RFI

RFI #: 194
Date: 9/25/2012
Job: EB-02 Keller Springs Lofts
Phone: 877-777-5115

Subject: Structural support for the radius feature above B3 unit

SHEET NUMBER  
**3.5A**  
 BLDG PLAN 'A'

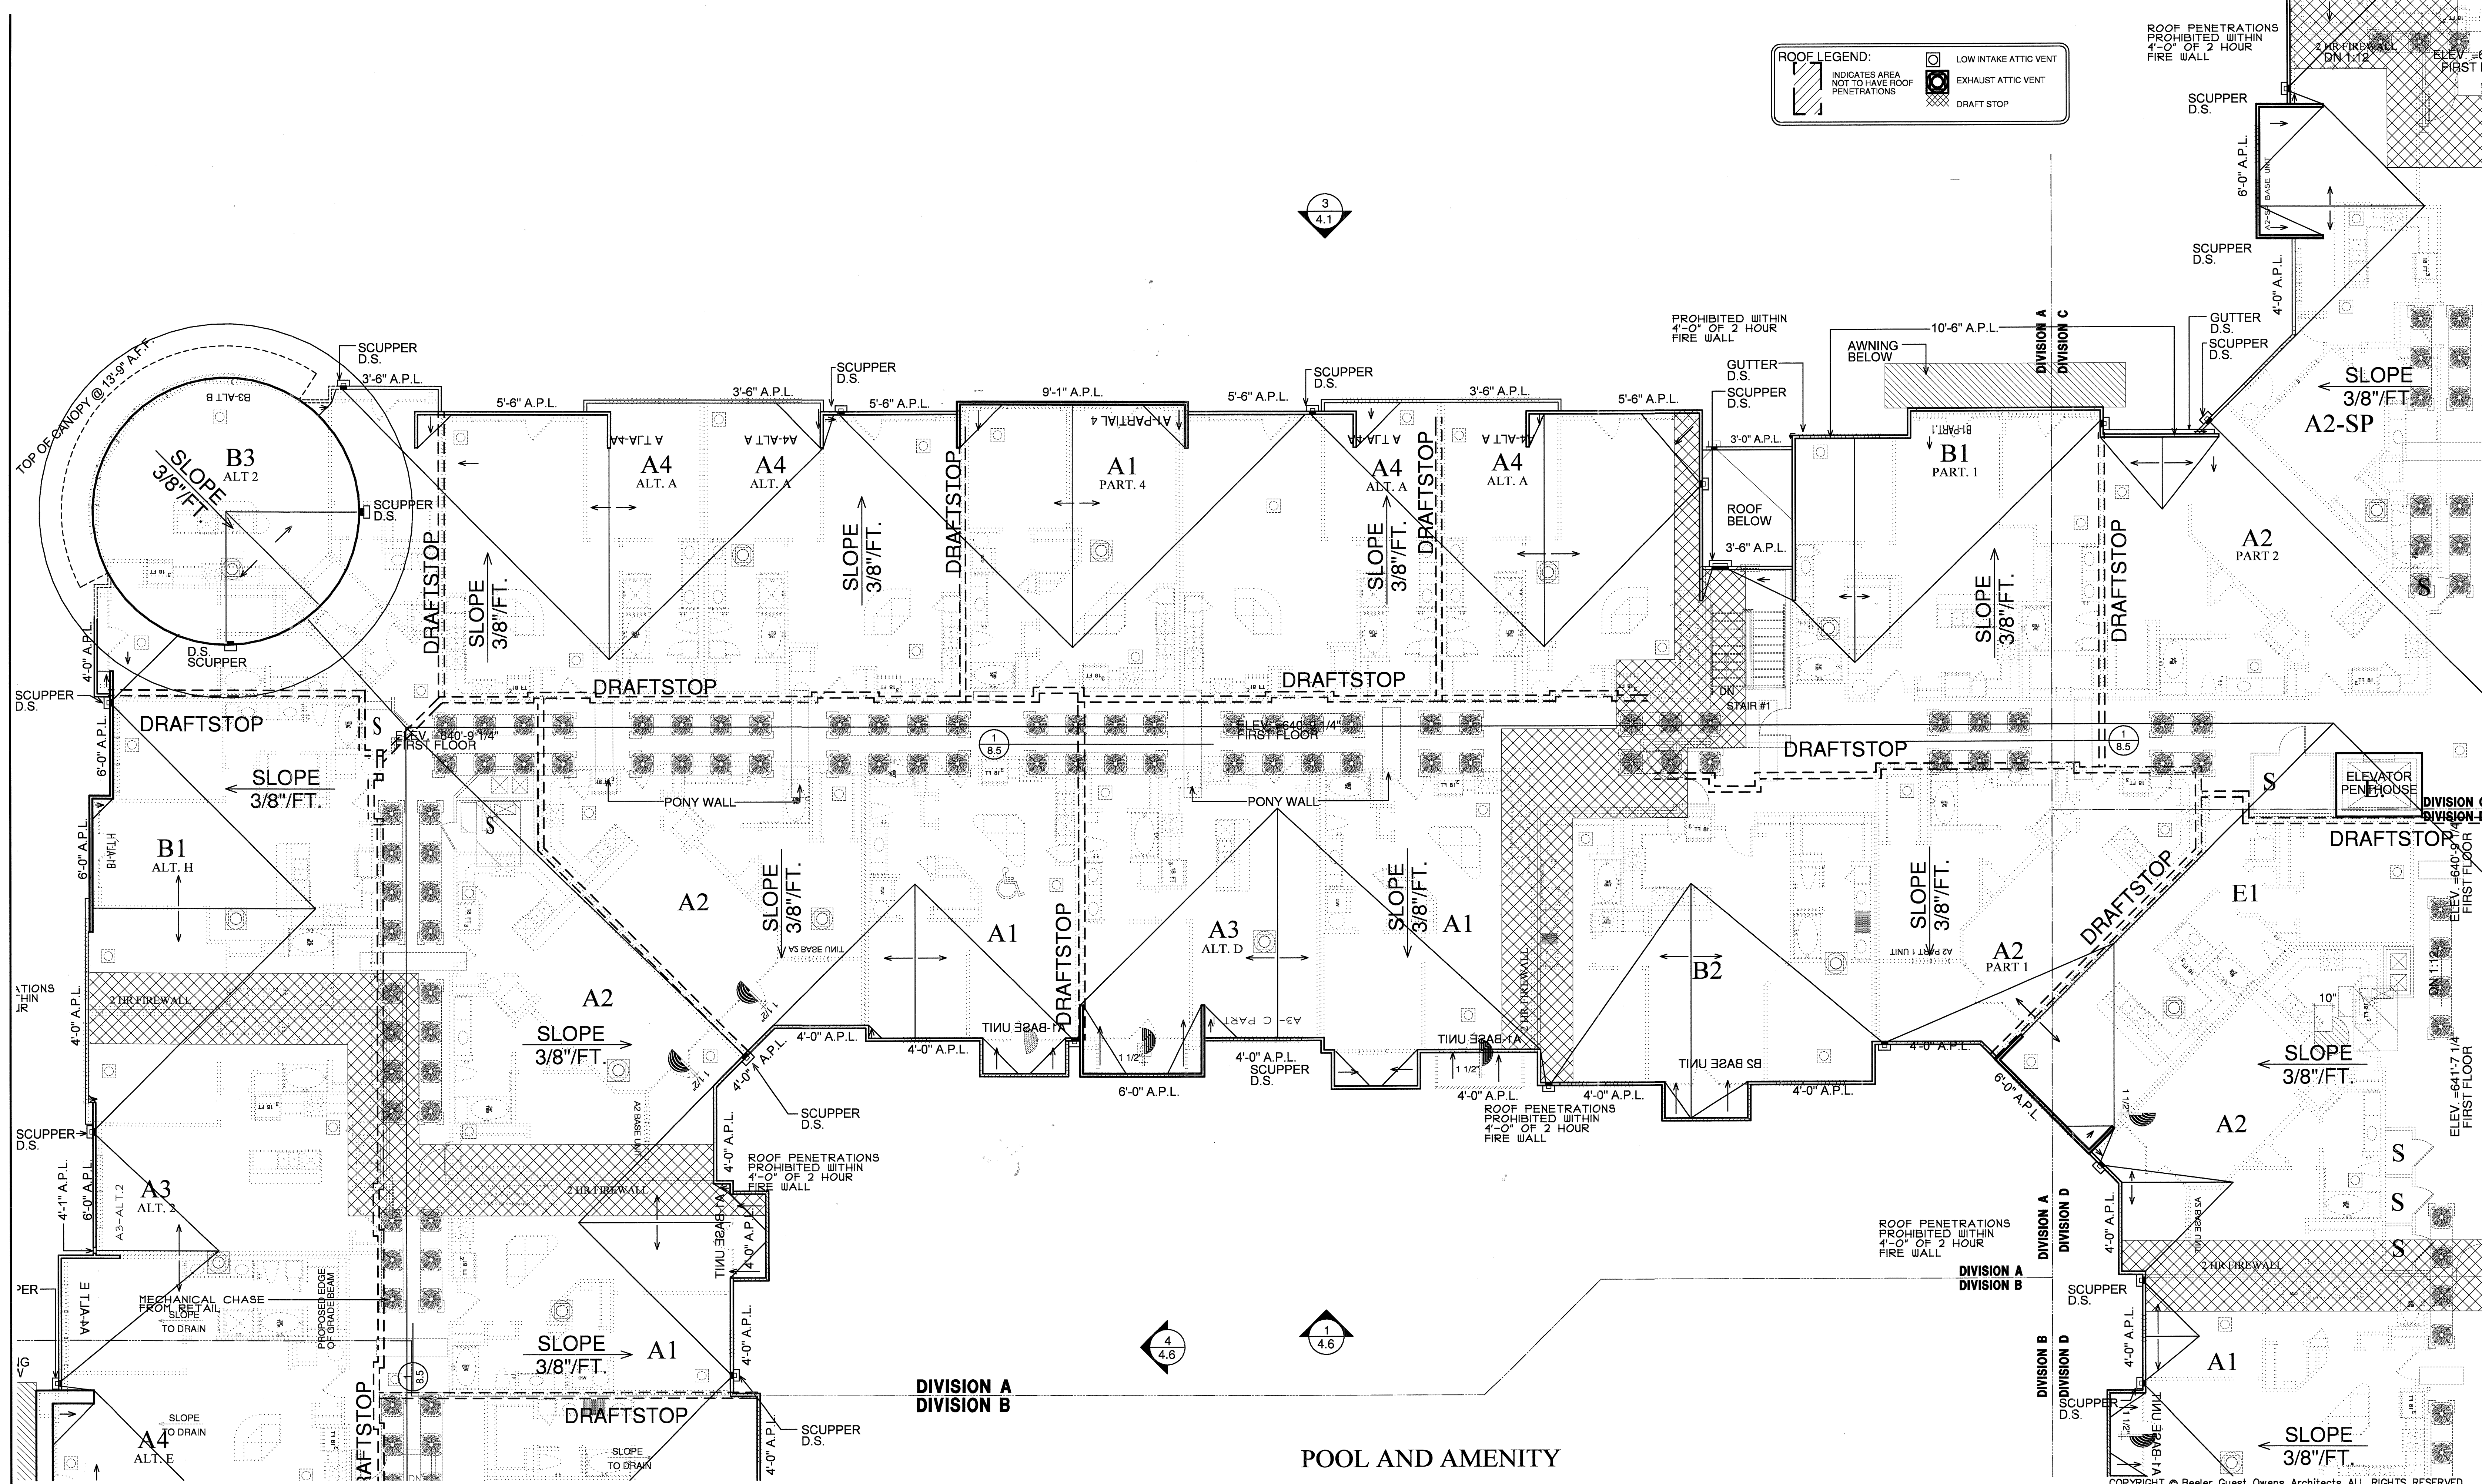
On the very northwest corner of turn section #2 we have the radius canopy feature on the roof. This area is located on the structural plans on sheet S2.41 and 3/S5.02. On structural sheet 3/S5.02 it is shown tied into the actual ceiling truss. However, on Panel Truss's approved drawings these are two separate trusses and they are not tied in. This is shown on Panel Truss sheet R02. I have drawn a very rough sketch showing how it's built and have concerns about proper anchoring of the piggy back trusses for wind shear. What you have is the flat ceiling trusses over the B3 unit with plywood roof decking. The flat trusses are R187- R197. Then on top of the roof decking you have the 870 piggy back trusses which form the radius feature. The problem I have is the R870 trusses need to be properly secured structurally for wind shear. I have spoken to Red River about this and they said Bob Cinciar with Panel Truss said they had to design it this way. They also said that PPO would need to determine how we secure it and what type of anchors, straps or clips will be needed.

Response:
Attach exterior ends of all piggy back trusses to framing/trusses below with CS18 coil strap. At interior end and along the length of all piggy-back trusses, attach to trusses/truss blocking (thru decking) at 24" on center with Simpson HGA10 clips. Fasten to piggy-back trusses with 4-SDS 1/4" x 1 1/2" screws. Fasten to supporting framing (thru decking) 4-SDS 1/4" x 3" screws.
